MONA OFFSHORE WIND PROJECT

Response to NRW Deadline 3 Submissions – Ecology (Terrestrial)

Application Reference: EN010137

Document Reference: S_D5_7

Figure 1-3: Outline drainage strategy

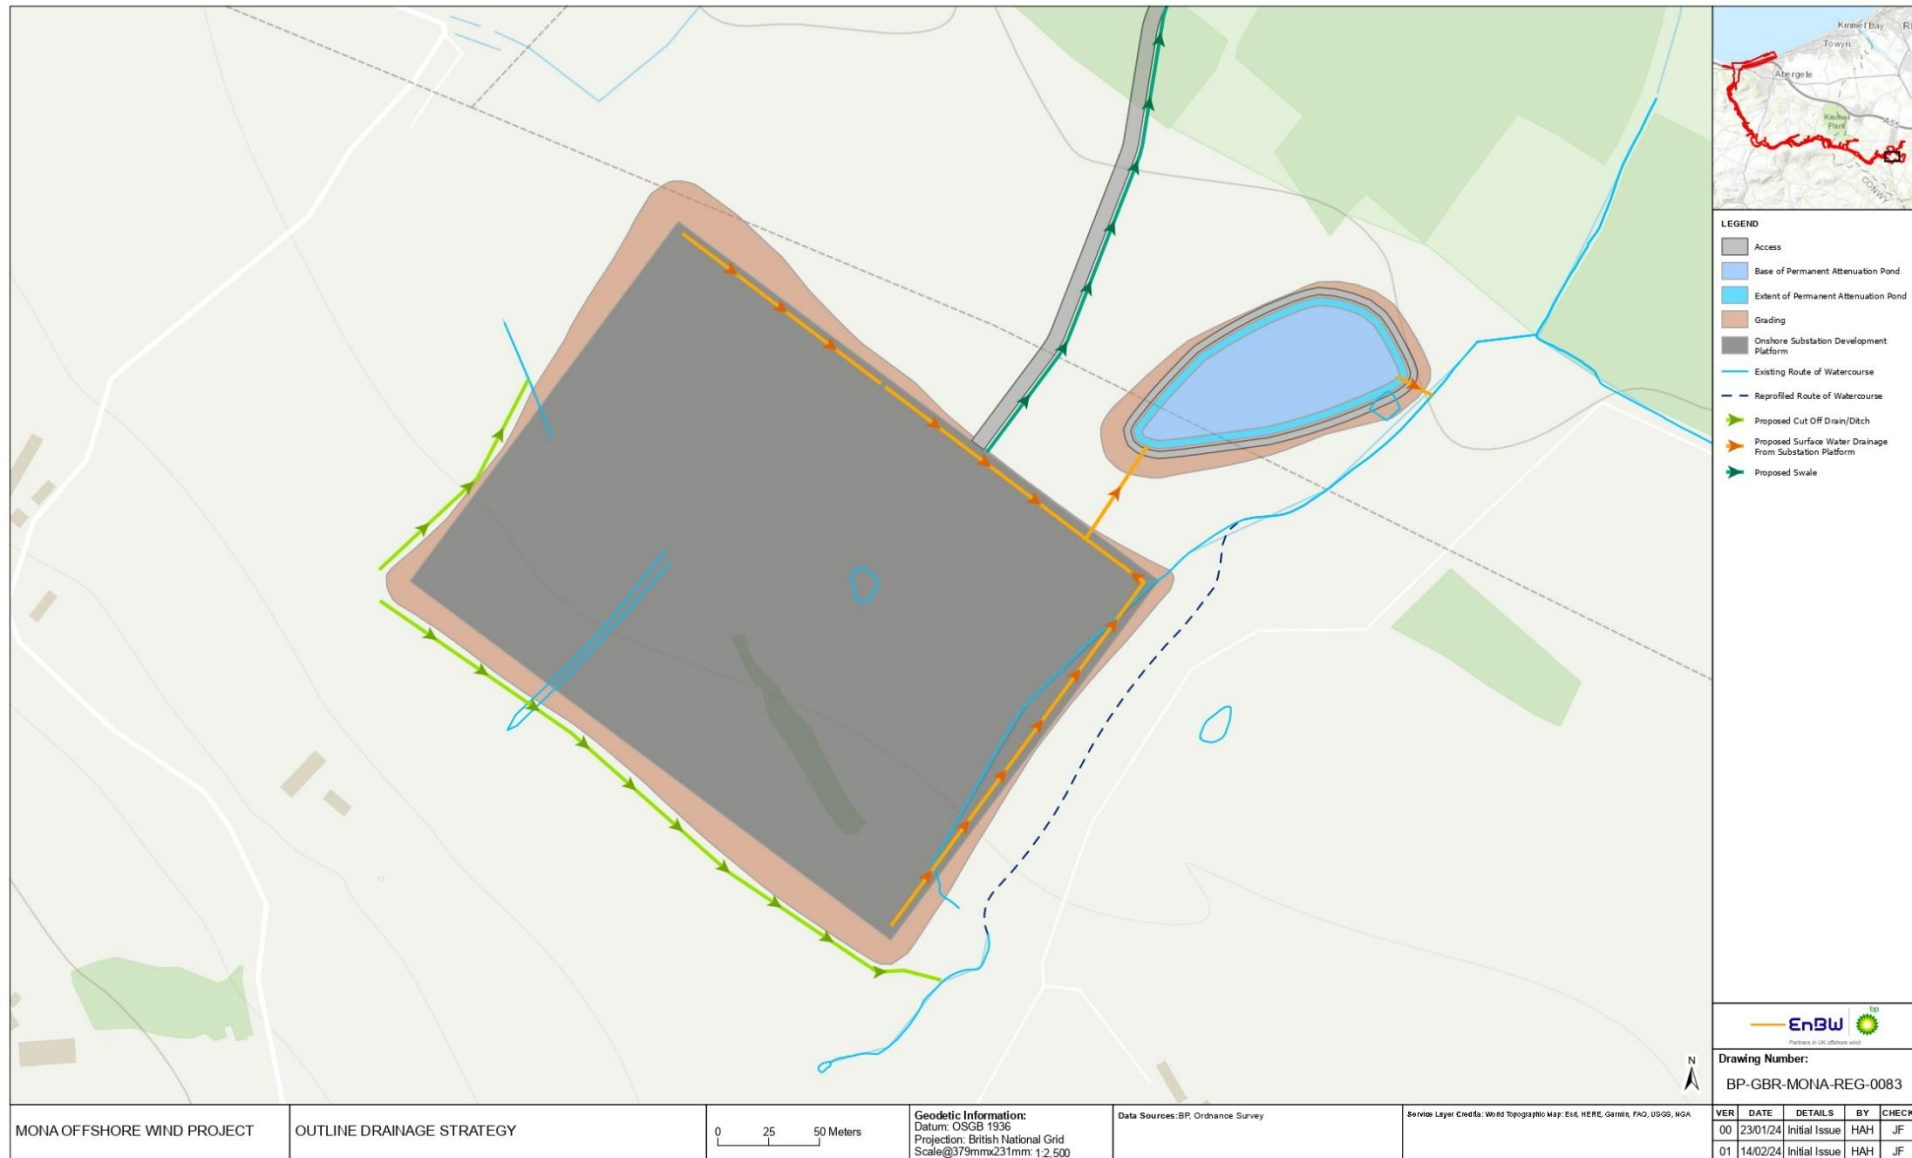
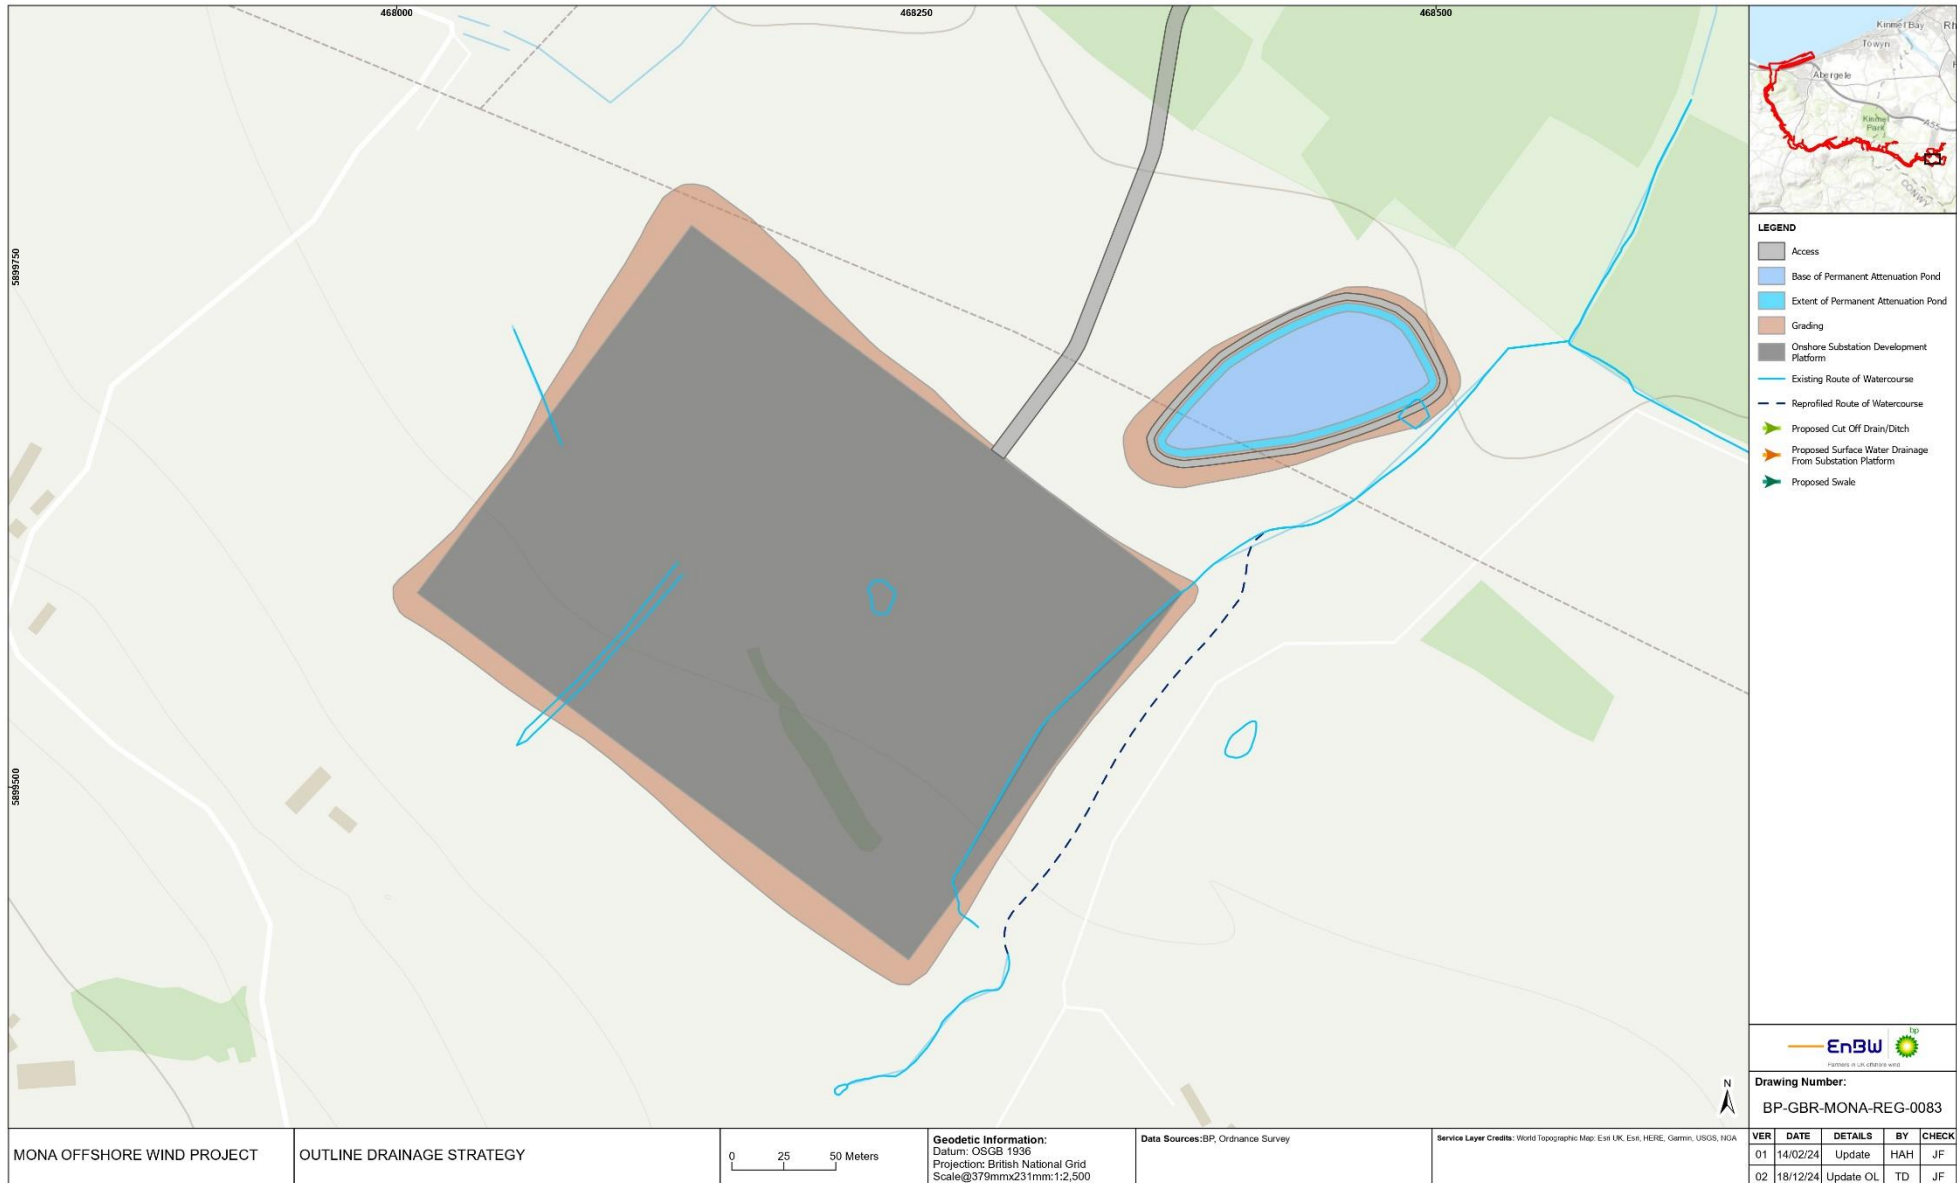
REP3-090.304	Appendix D – Outline Great Crested Newt Mitigation Strategy 9. No consideration appears to have been given to the issues and impacts caused by the installation of surface water gully pots and amphibians.	A section on operational drainage has been added to Appendix D of the Outline LEMP (J22 F03) to confirm that surface water drainage will include measures to avoid impacts on GCN (Section 1.4.7). This section also cross references to the information provided in the outline Operation Drainage Management Strategy (APP-231).
REP3-090.305	Appendix D – Outline Great Crested Newt Mitigation Strategy 10. We advise that subsequent revisions to the GCN Conservation strategy include (a) amphibian friendly surface water management systems, and (b) long term GCN surveillance proposals include any proposed SUDS ponds.	Please refer to the Applicant's response to REP3-090.304. The SUDS attenuation pond will be subject to GCN surveying as part of the post-translocation GCN monitoring if it is found to be holding water at the time of the surveys (and thus could support breeding GCN). An amendment has been made to Appendix D of the OLEMP to clarify that the SUDS attenuation pond will be included within the post-translocation GCN monitoring programme (J22 F03).
